ASSESSMENT REPORT

Section 75W Modification Materials Recovery Facility (06_0052 MOD 2)

Figure 4: Proposed Noise Barriers

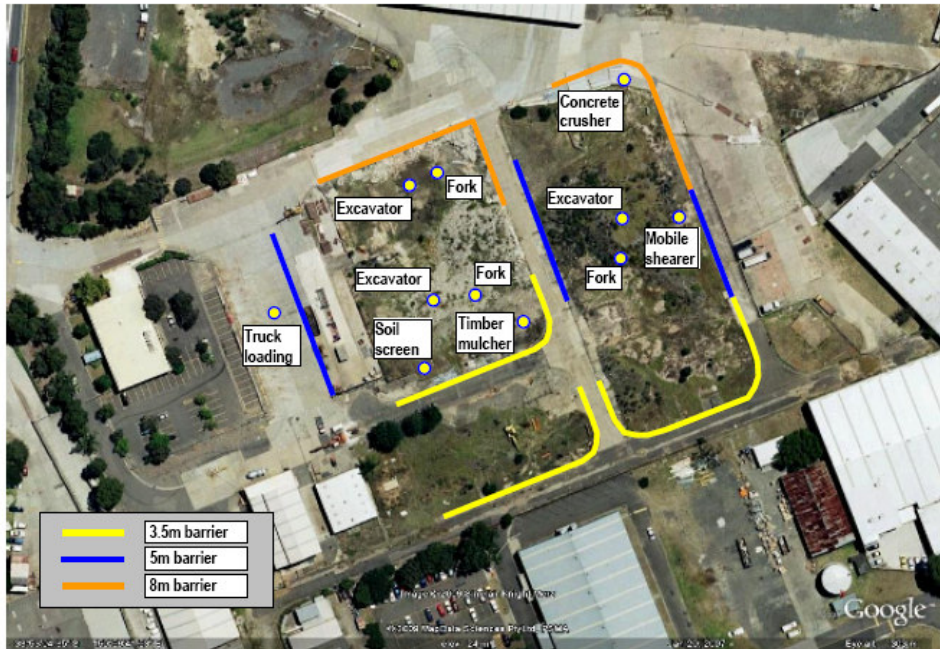
container stacks. The container stacks are only 5m high, whereas the approved concrete barriers are required to be 8m high on the northern perimeter of the site to ensure that activities at the premises are shielded from the noise sensitive receivers to the north.

The modification application does not include a prospective noise impact assessment that models the noise impacts from the operation of the MRF with acoustic barriers that are 5m high instead of 8m high. Consequently, the department is not satisfied that the proposed shipping containers are either adequate to shield all processing activities at the premises from noise sensitive receivers, or sufficient to attenuate noise impacts to comply with the existing noise criteria in the approval.

In addition, the modification application does not include a prospective noise impact assessment modelling the noise impacts of the MRF with acoustic barriers that are up to 3m lower than those required in the approval. Noise measurements of the MRF in operation with the container stacks were carried out by the Proponent in June 2011. These measurements appear to indicate that the

Figure 2: Acoustic Barriers

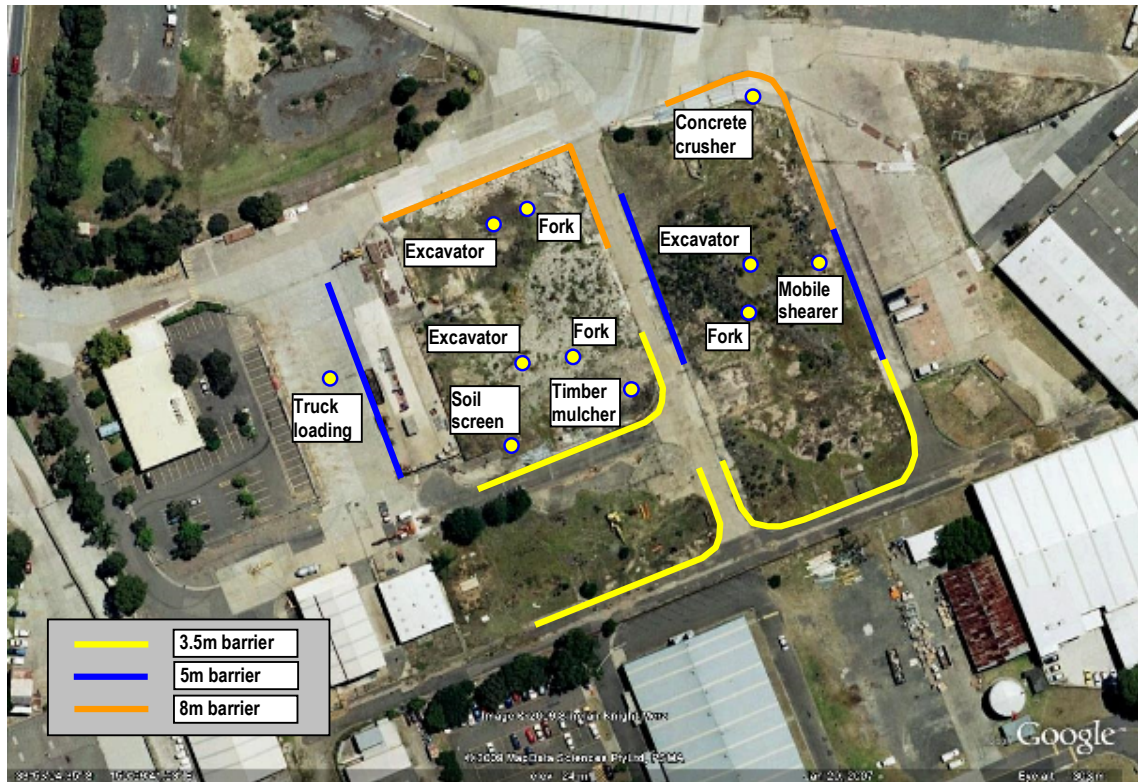
The modification proposal involves placing shipping containers on the site permitter only, where they are intended to function as acoustic barriers for the approved operation. However, the approved barrier layout included a number of internal barriers, which were required to segregate stockpiled material on the site.

Without the internal barriers, it would be difficult to manage stockpiles and separate waste in an orderly manner. The operation of the MRF without the internal barriers has led to a range of compliance issues including dust emissions, excessive stockpiles heights, stormwater contamination and the uncontrolled ignition and burning of waste. In addition, there is a significant risk of cross-contamination between raw materials and processed product.

The Proponent has not addressed the matter in the Response to Submissions. The department is therefore not satisfied that the barrier layout in the proposed modification adequately deals with the site's operating requirements.
